**HISTORIC PRESERVATION BOARD  
CITY OF PORTLAND, MAINE**

**PUBLIC HEARING  
414 FORE STREET**

**TO:** Chair Romano and Members of the Historic Preservation Board  
**FROM:** Deb Andrews, Historic Preservation Program Manager  
**DATE:** April 25, 2013  
**RE:** May 1, 2013 Public Hearing

**Application For:** Certificate of Appropriateness for Exterior Alterations and Rooftop Mechanicals  
**Address:** 414 Fore Street  
(corner of Fore and Dana, with frontage on Wharf)  
**Applicant:** Gould Company LLC.  
**Architect:** Richard Borrelli, Harriman Associates

EXTERIOR ELEVATIONS

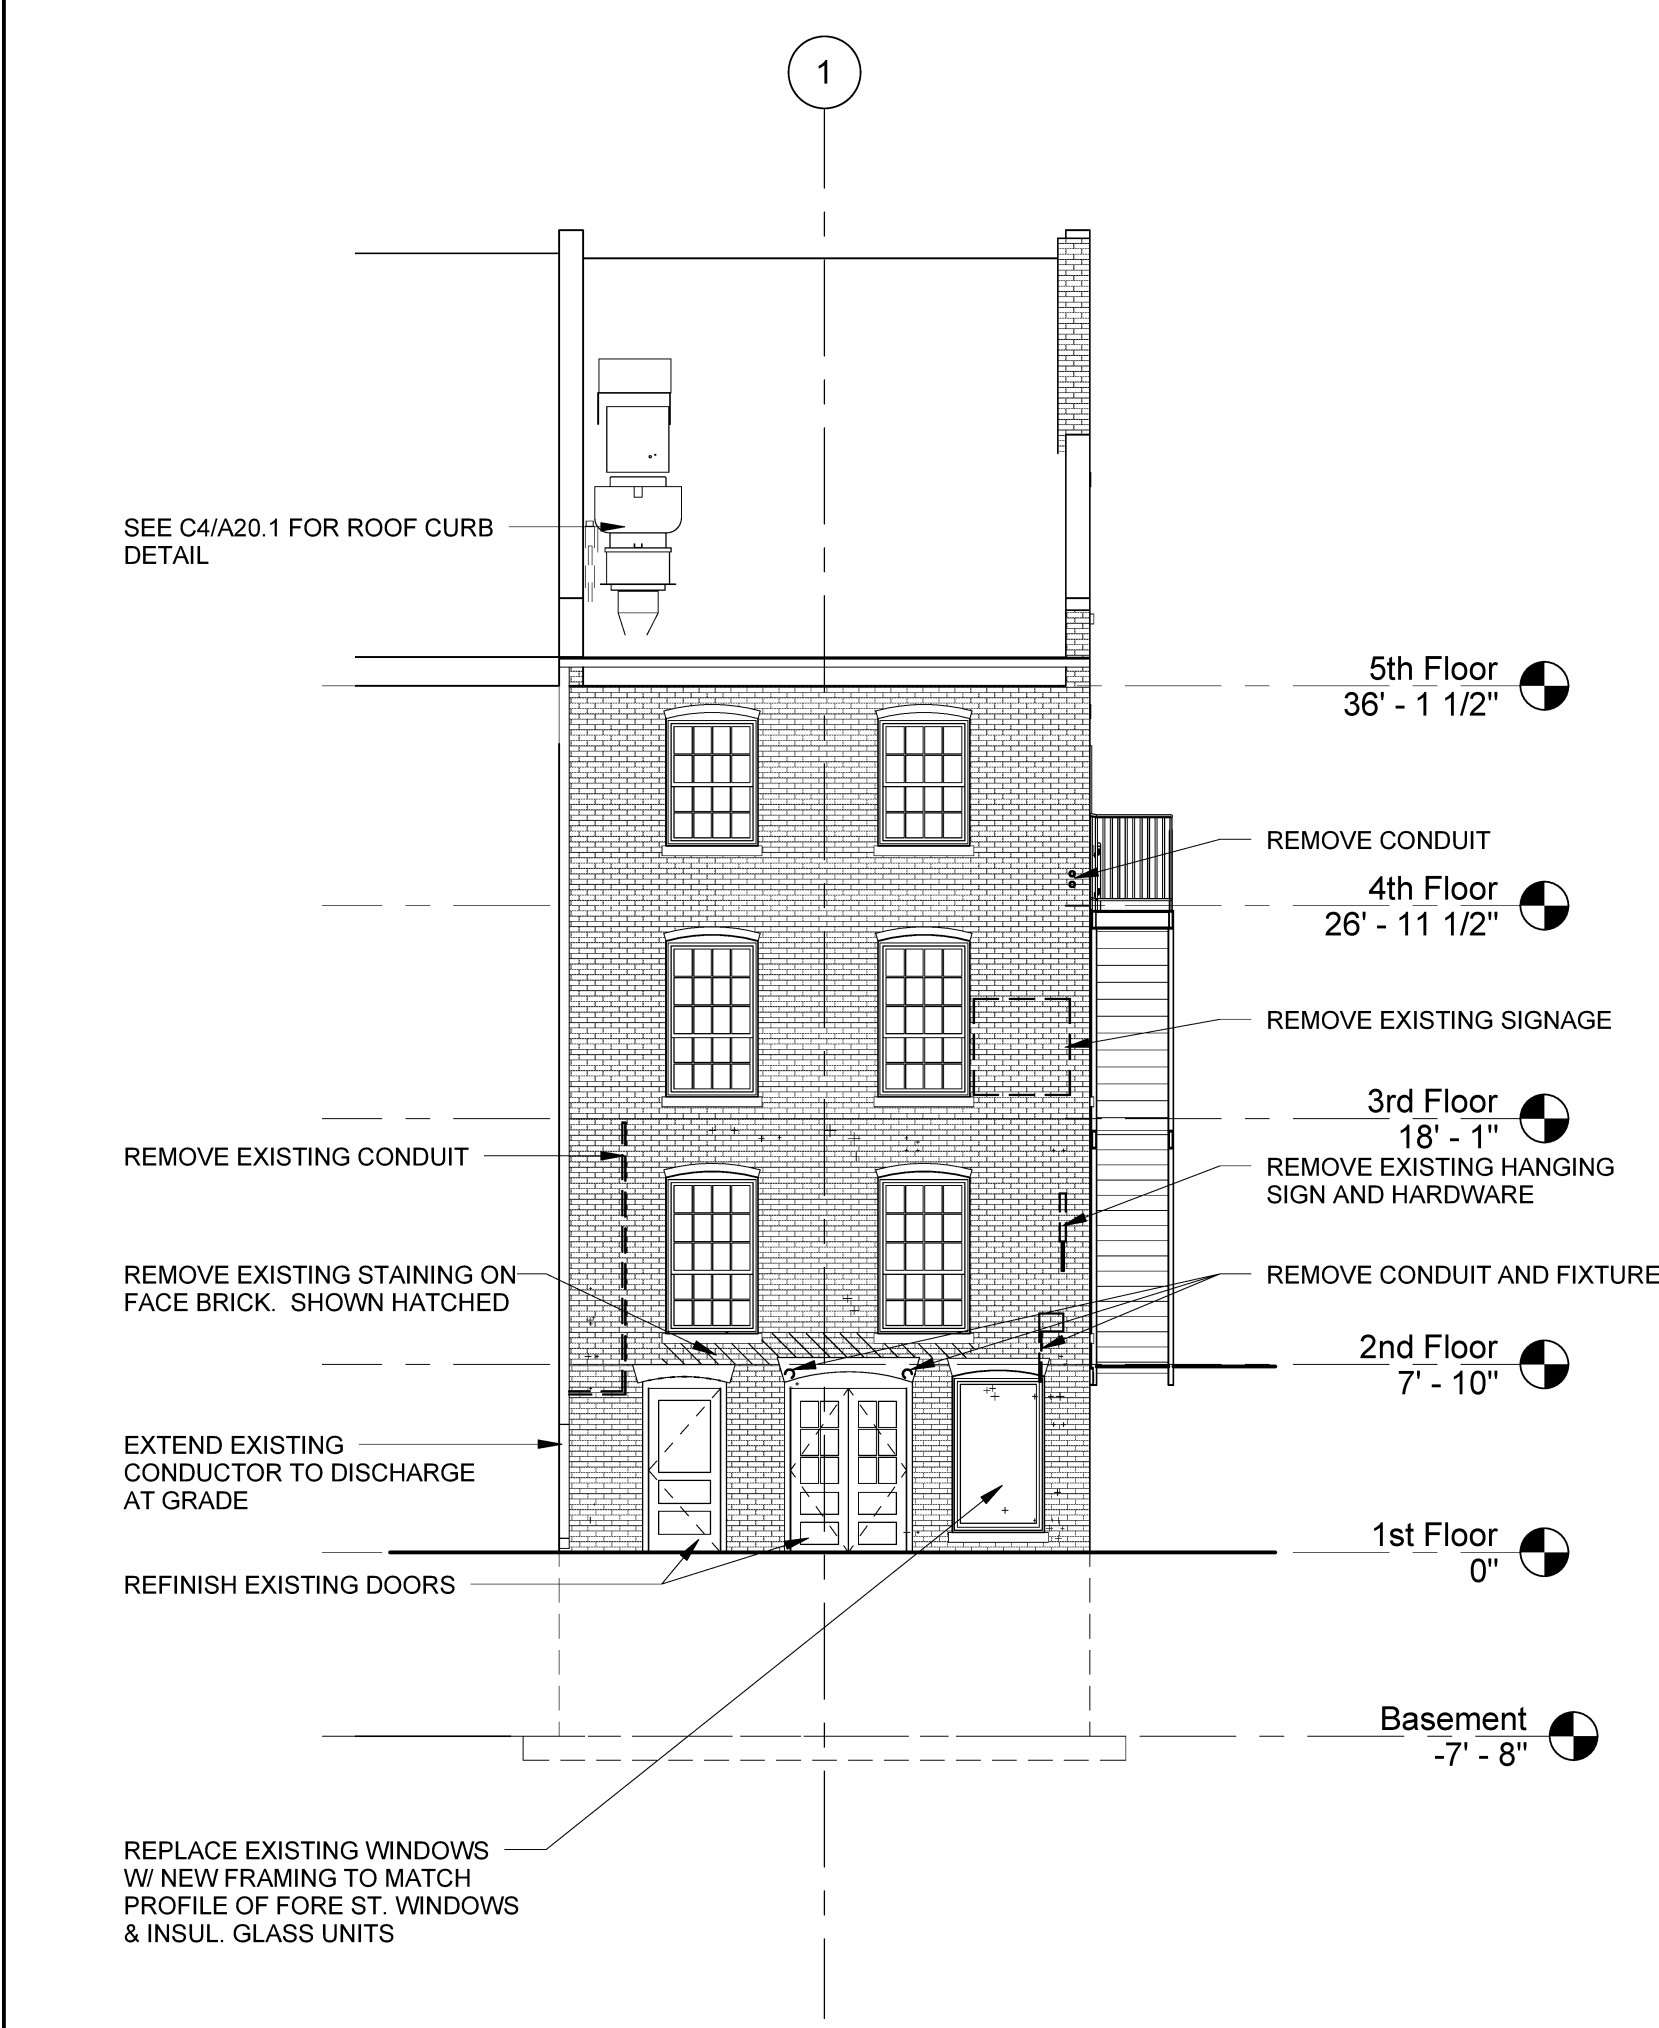
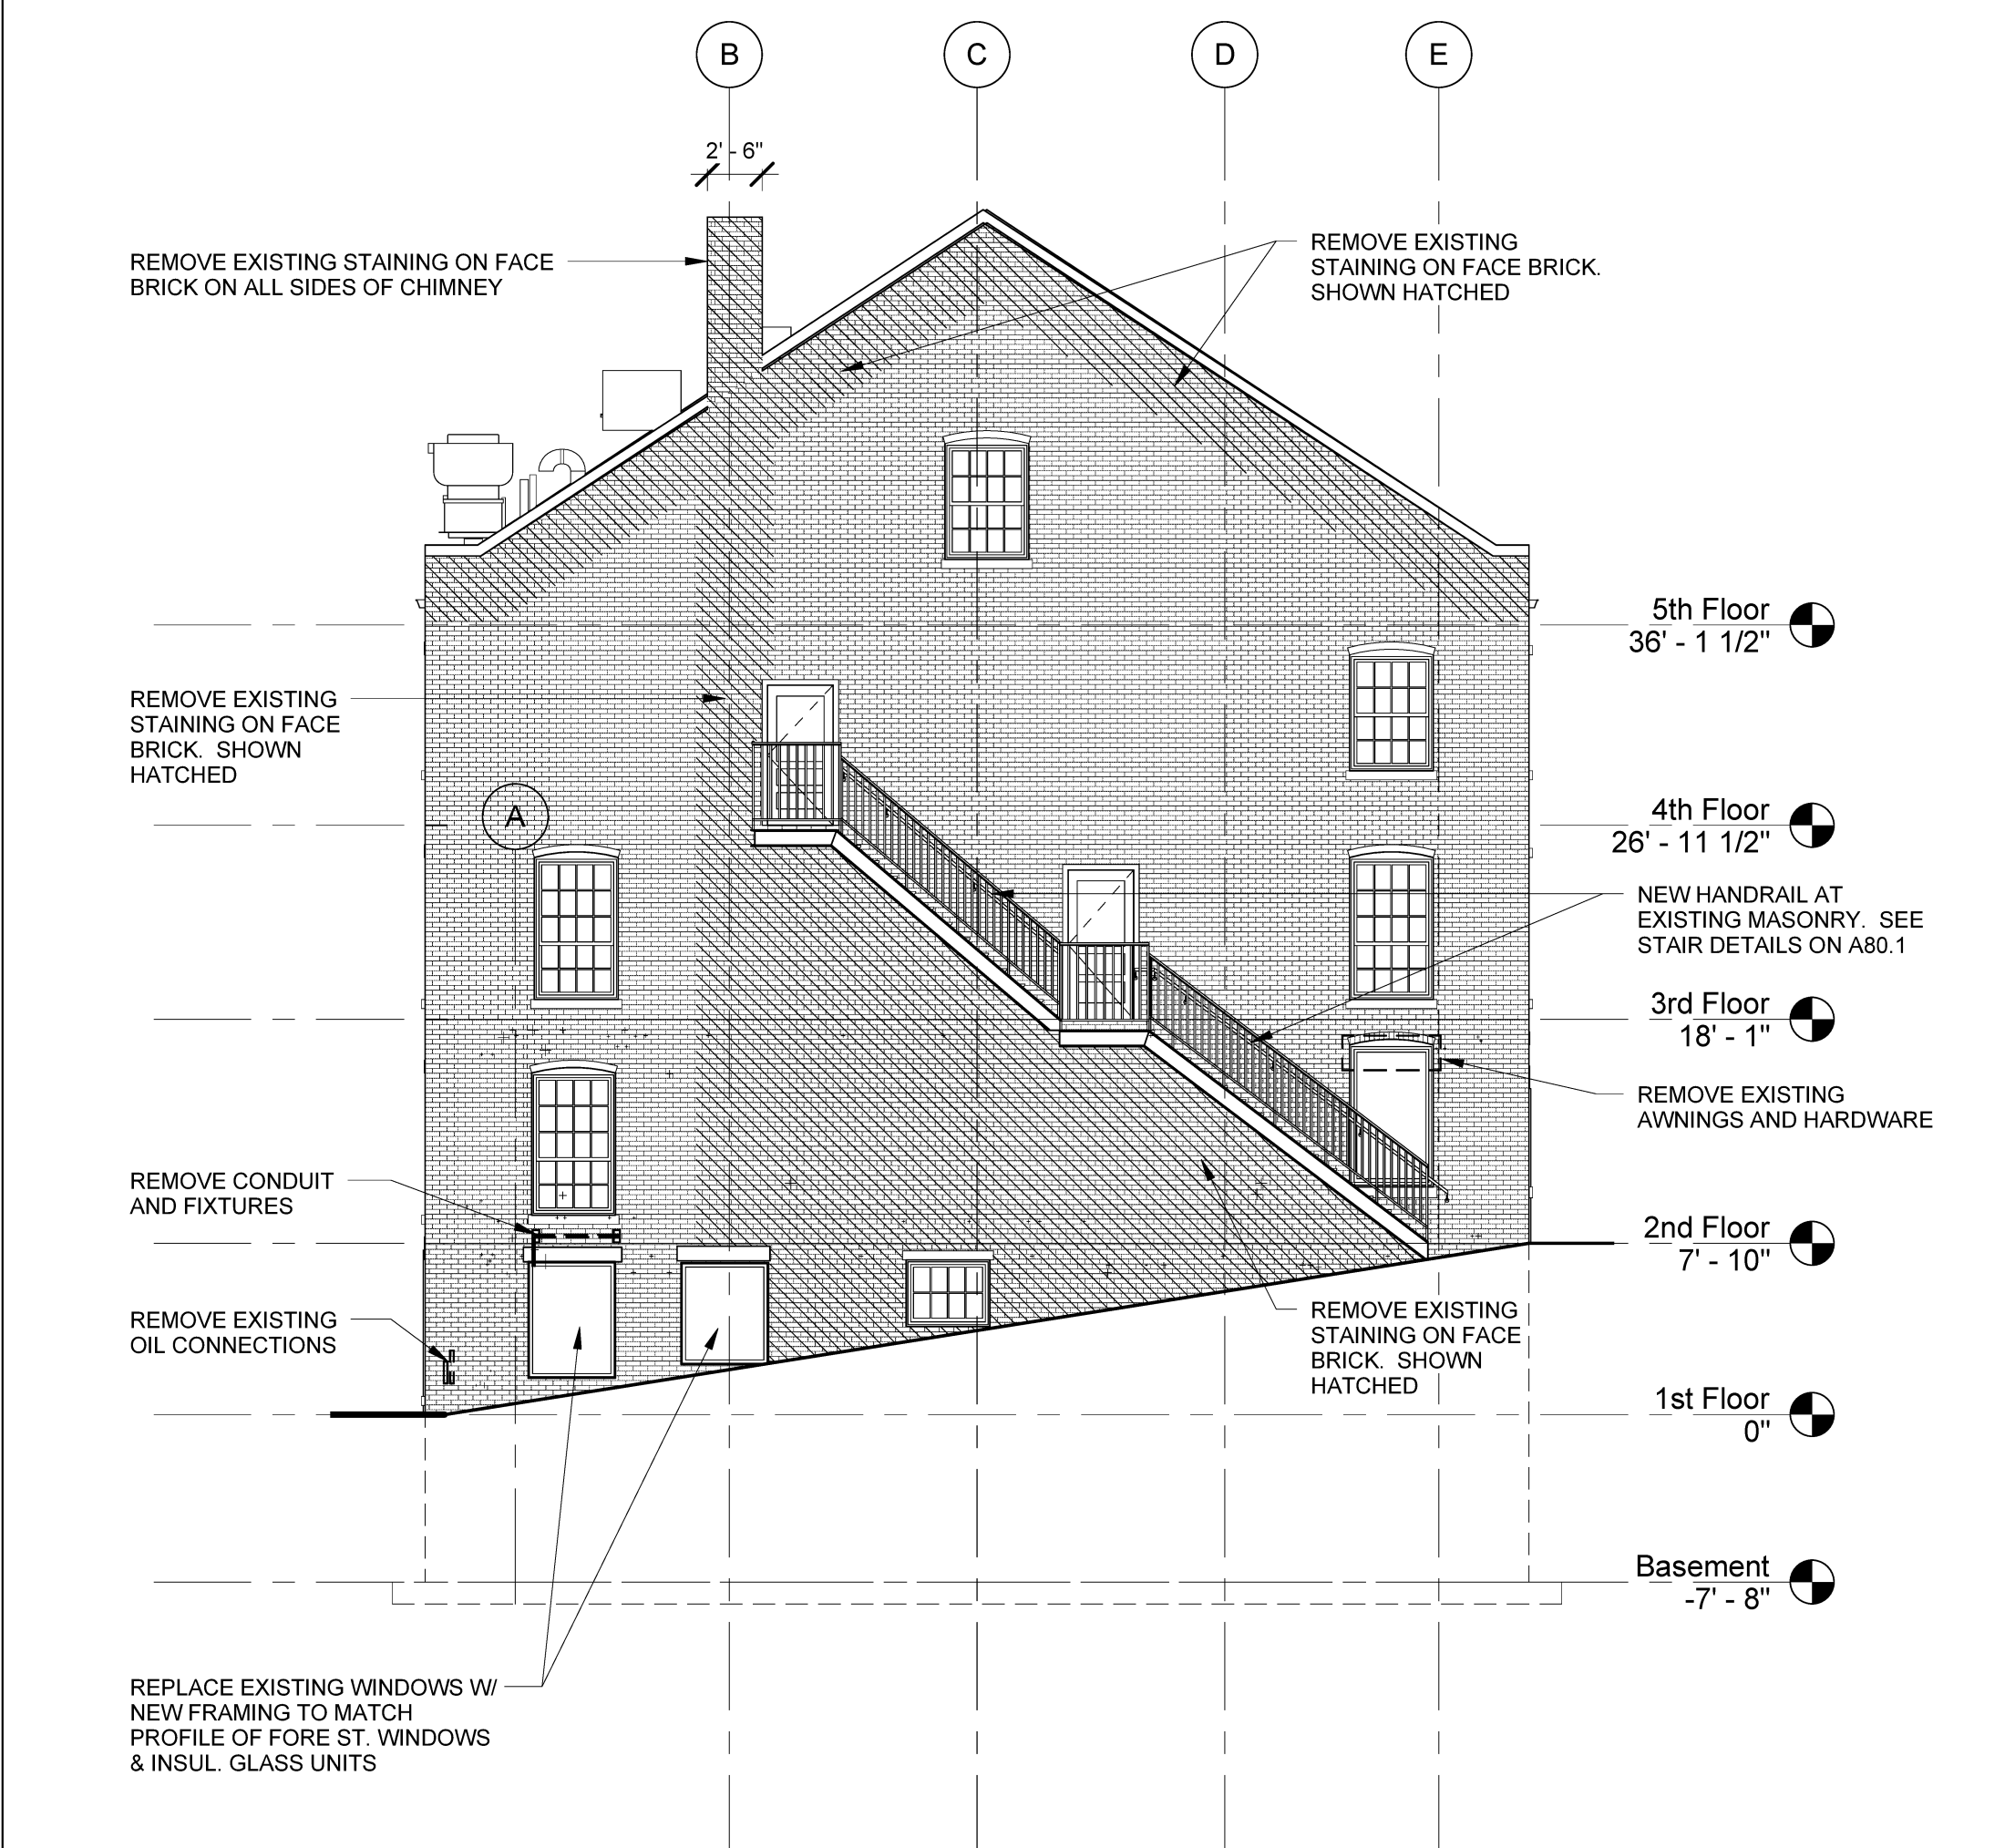
More significant alterations are proposed for the Wharf Street roof plane. Here, two condensers and an exhaust fan are proposed to be installed in a vertical alignment close to the eastern edge parapet wall. To help obscure the mechanical equipment from some vantage points, a metal screen is proposed.

Staff applauds the applicant's intention to clean up the building and remove some of the small accretions that have undermined its architectural clarity. The building certainly warrants this attention. It is somewhat unfortunate, then, that the proposed new use will necessitate fairly substantial changes to the roof, particularly since it is one of the few roof planes facing Wharf Street that does not currently feature various rooftop additions. Mr. Borelli is mindful of the high degree of visibility of this roof plane and has worked to organize and minimize the impact of these rooftop units. The role of the Board is to determine whether the proposed scheme is successful in this regard.

considered as well. Unfortunately, this building offers little opportunity to hide mechanicals, as it is fully exposed on three sides. It would seem that the Board's role in this instance is to ensure that all opportunities for minimizing the equipment's visual impact have been fully explored. In staff's view, factors for consideration should not include the applicant's possible future interest in adding a rooftop deck.
